**Rampion 2 Wind Farm
Category 8: Examination
Documents
Applicant's Responses to
Brighton and Hove City
Council's Deadline 1
Submissions
Date: March 2024
Rev A**

Application Reference: 8.48
Pursuant to: The Infrastructure Planning (Examination
Procedure) Rules 2010, Rule 8(1)(c)(i)
Ecodoc number: 005118964-01

Figure 15.32d  
 Viewpoint 7: Beacon Hill Rottingdean

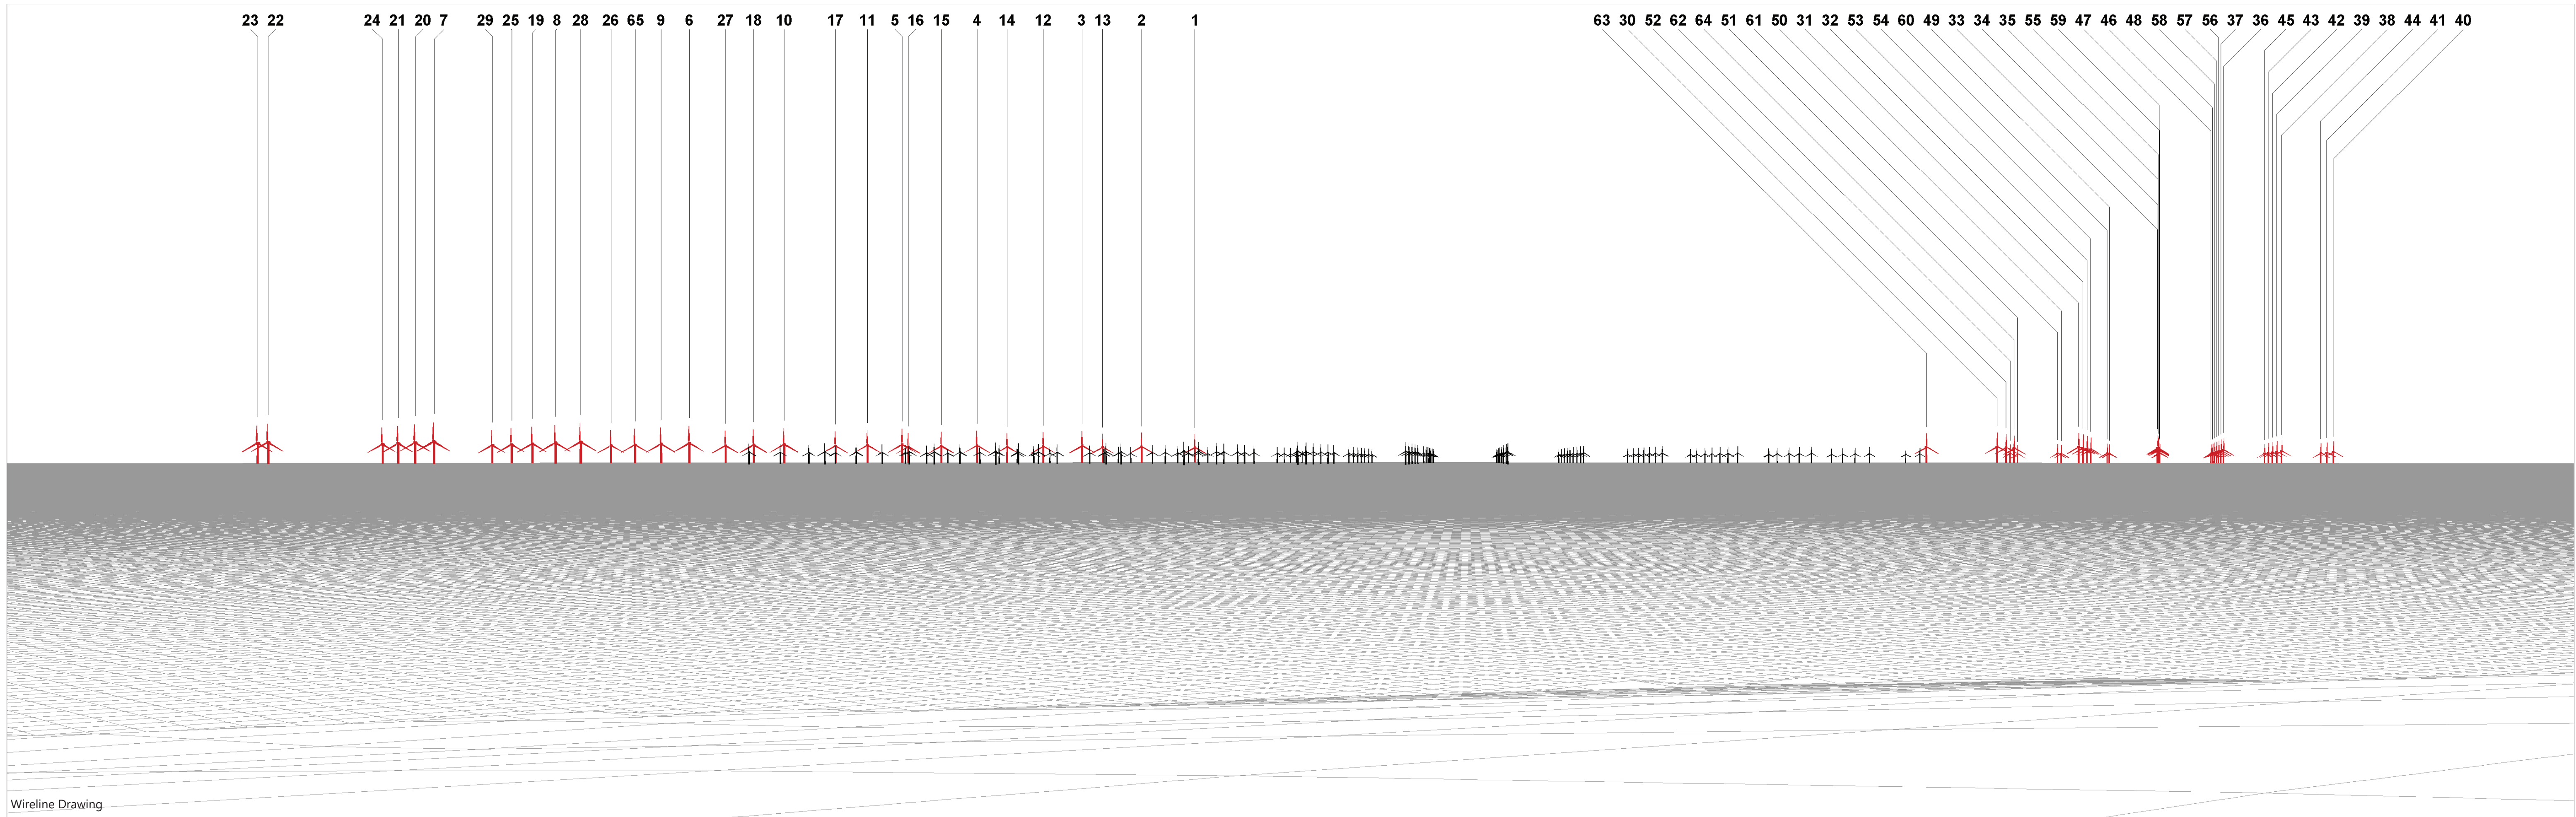
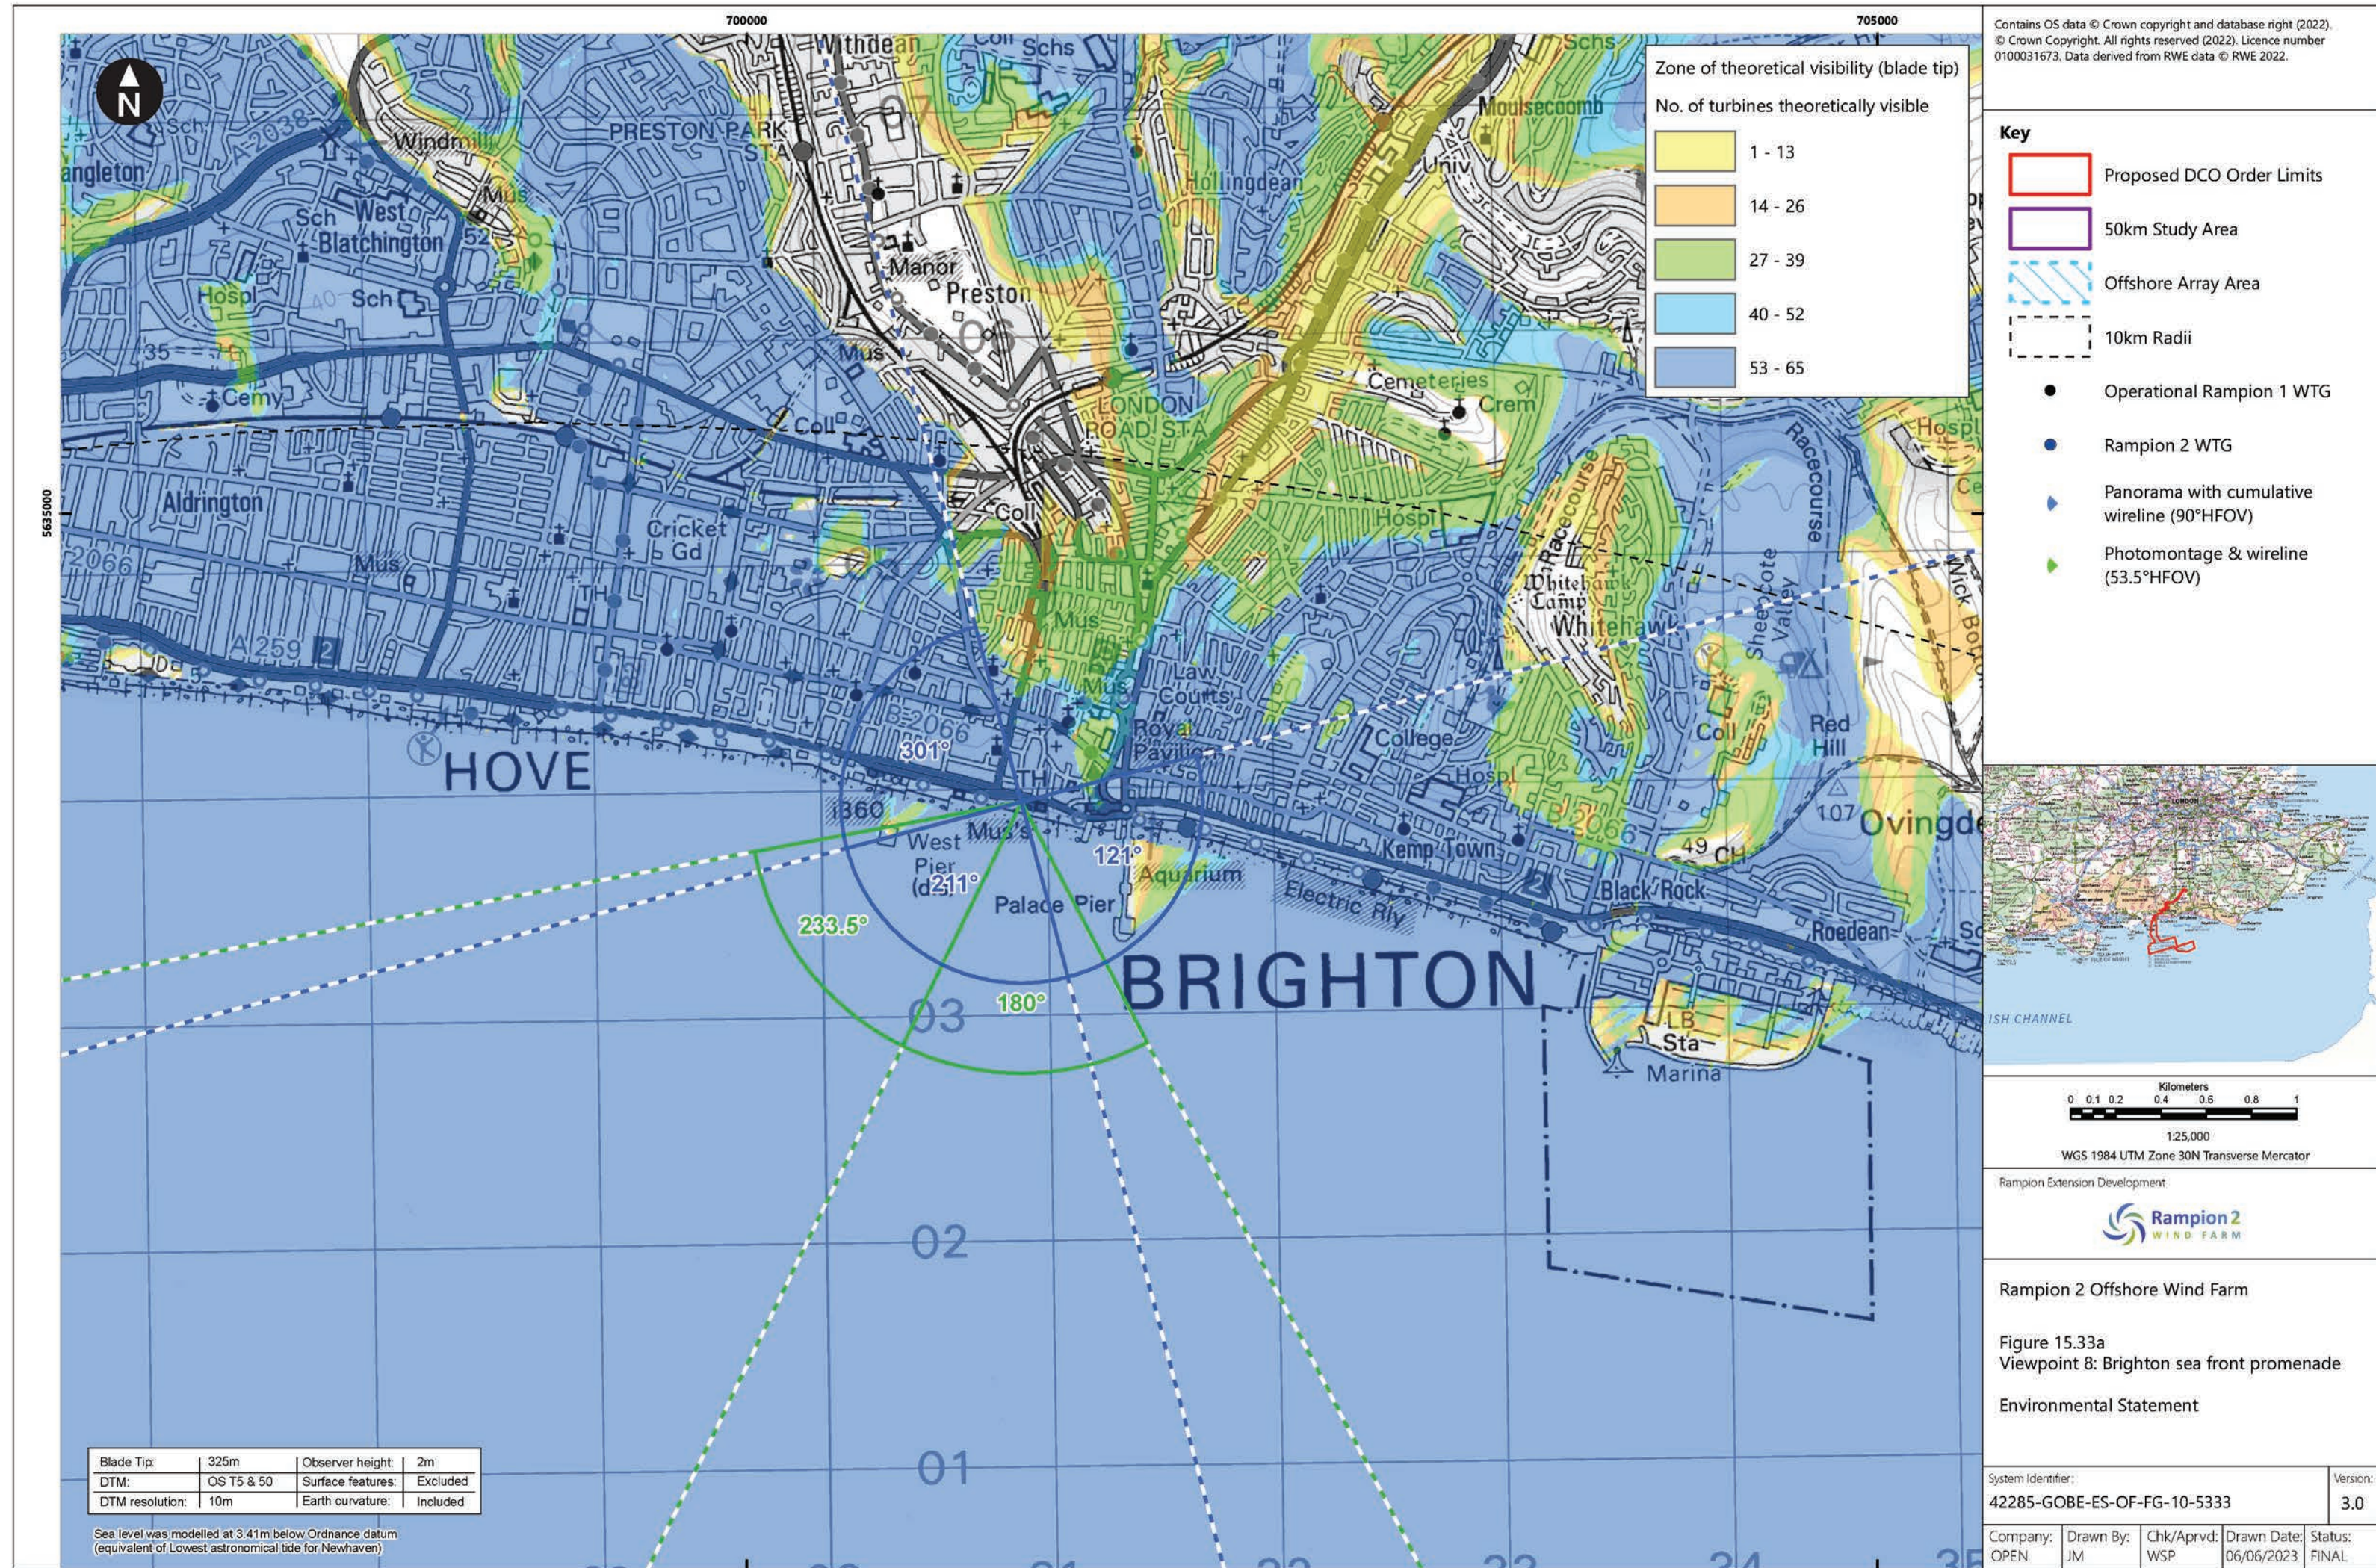
4.7 to 4.8 4.7 Throughout the process, and as is evident in the SLVIA, there has been an almost singular focus on the landscape, seascape and visual impact on the nationally designated landscapes, particularly South Downs National Park (SDNP) and the Sussex Heritage Coast. While the impact on these designations is understood, there is also a need to take into account the wider impacts, including on Brighton and Hove. For example paragraph 15.7.23 of the SLVIA refers to ‘good design’ minimising the impact on the special qualities of these protected areas, echoed at paragraph 15.7.25, 15.7.26, and 15.7.27. There is no mention of mitigating the impact on Brighton and Hove’s sensitive coastline. Further, we note in relation to paragraph 15.7.27 that BHCC did not have an opportunity to comment on the revised layout following responses to the PEIR as we were not invited to the April 2022 meeting at which it was discussed before being finalised.

The design principles described in Section 15.7 of **Chapter 15: Seascape, landscape and visual impact assessment, Volume 2** of the Environmental Statement (ES) **[APP-056]** have contributed to reducing the magnitude of change on views from Brighton seafront (Viewpoint 8) and Rottingdean (Viewpoint 7) from ‘High’ magnitude assessed in the Preliminary Environmental Information Report (PEIR) published as part of the first
